RE: New Suncadia Boundary Line Adjustment (BL-17-00005)

TO: All Staff
FROM: Justin Turnbull, County Surveyor 
DATE: May 30, 2017
SUBJECT: County Survey Review of Boundary Line Adjustment BLA-17-00005

DWN BY DLP	DATE 2/2014	JOB NO. 131201
CHKD BY GW	SCALE 1" = 100'	SHEET 1 OF 3

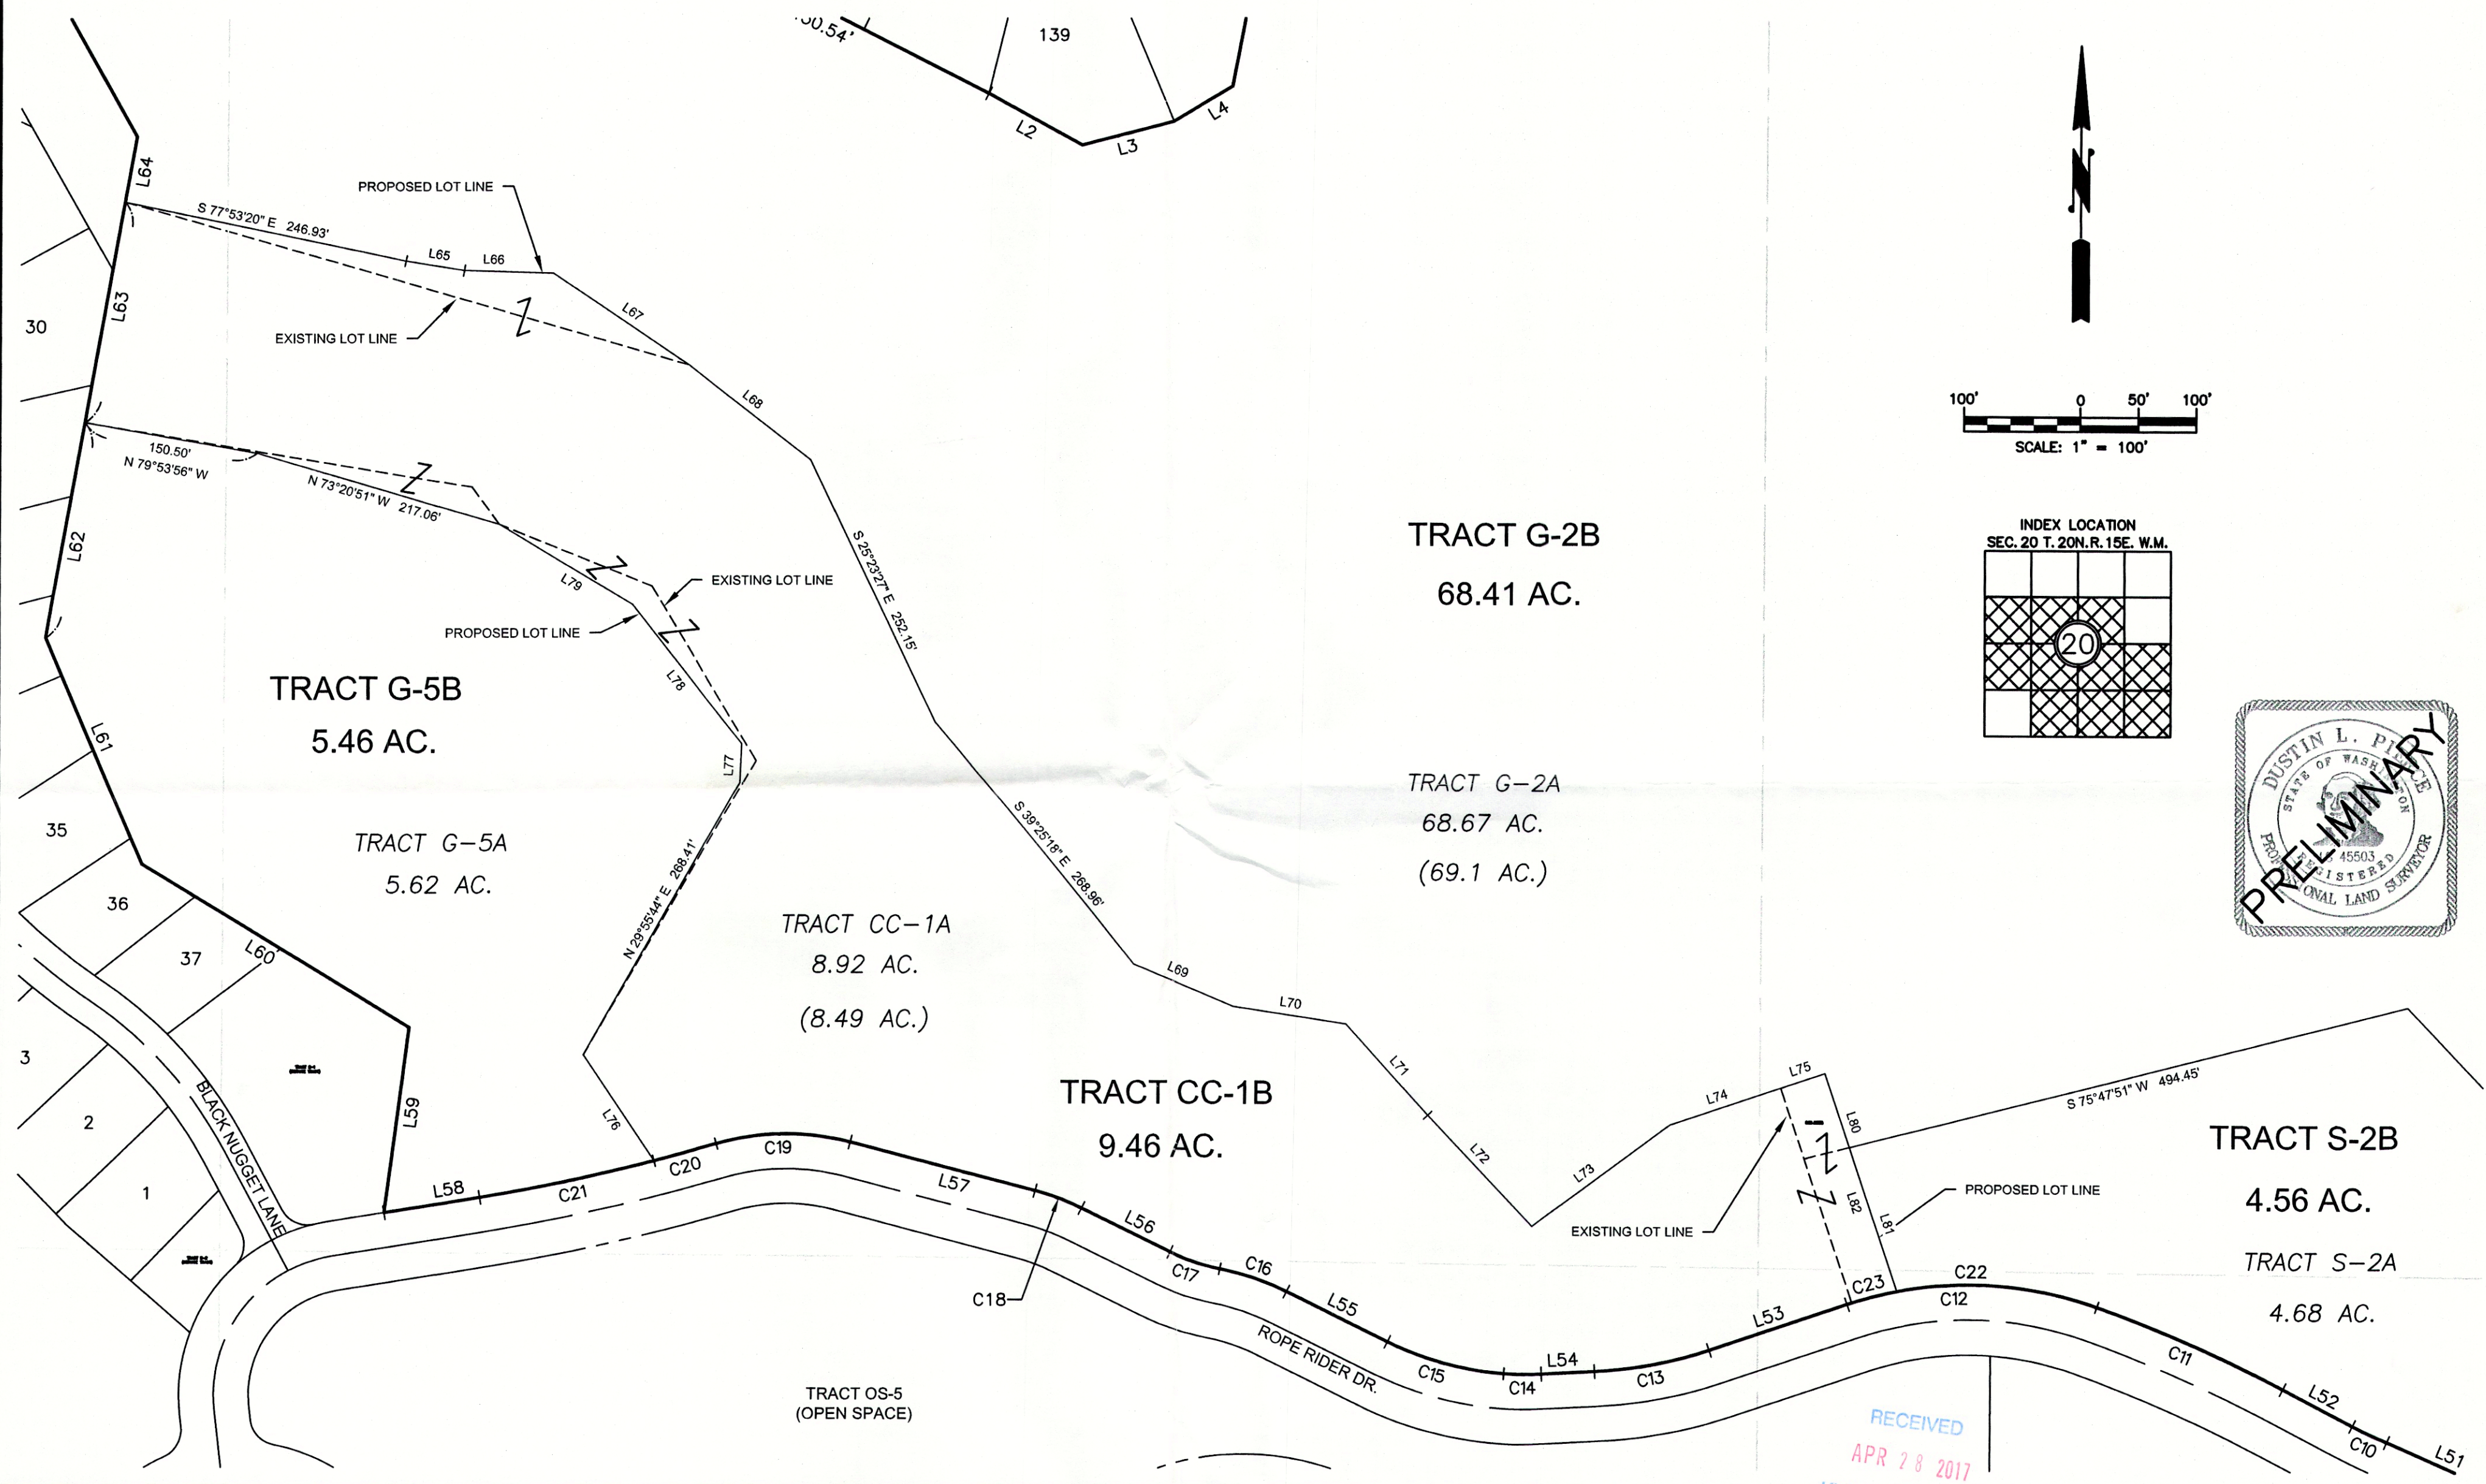
2. Sheet 1 shows some trimmed text at the top of the page, and text less than 0.08" in height near the lower left corner.
3. Roadways should be shown with name, width, ownership, Easement or R/W and surfacing (EX: Brown Rd – 60' Wide County R/W – Paved)

4. I believe the date on sheet 1 to be incorrect.
5. Basis of Bearing should be noted or stated.
6. Survey procedures statement should be shown.
7. Purpose of survey statement should be shown.

DWN BY	DATE	JOB NO.
DLP	2/2017	131201
CHKD BY	SCALE	SHEET
GW	1" = 200'	2 OF 3

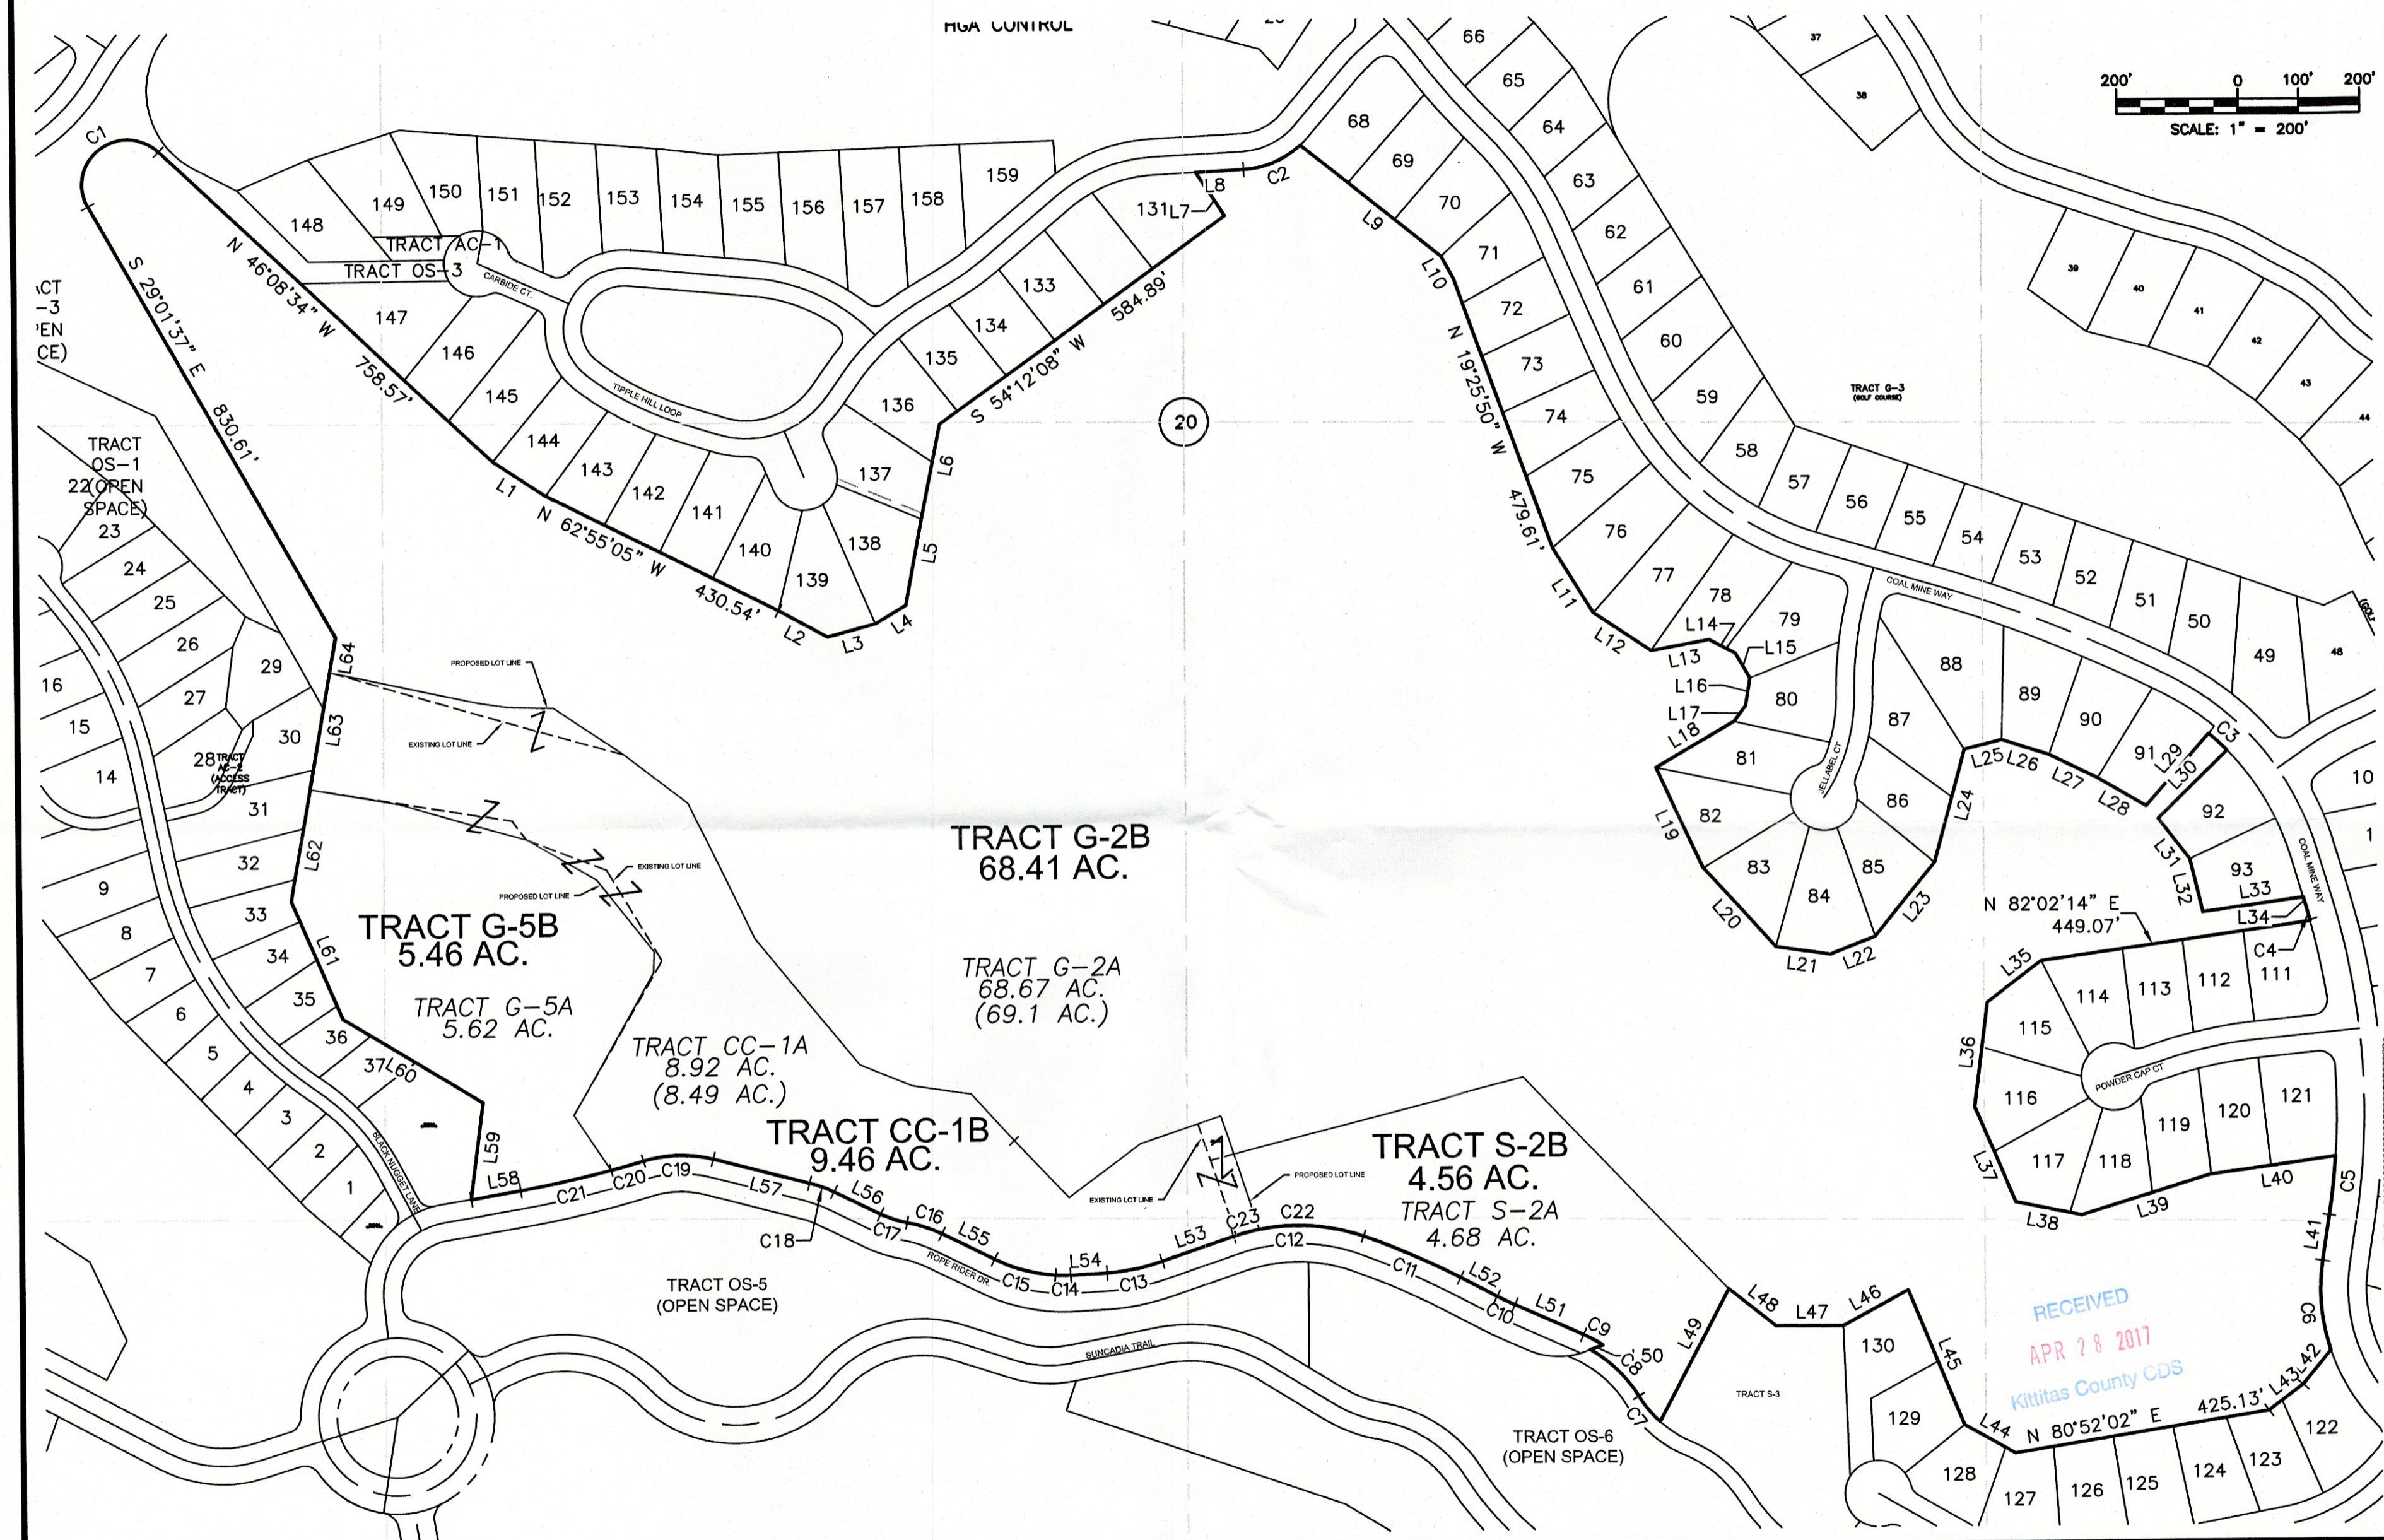
8. Controlling corners or monumentation should be shown or noted.
9. Sheet 2 shows multiple instances in road names, ex lot line labels and tract labels that do not meet 0.08" minimum text size. Additionally, there is some text trimmed near the top and left side of the page.
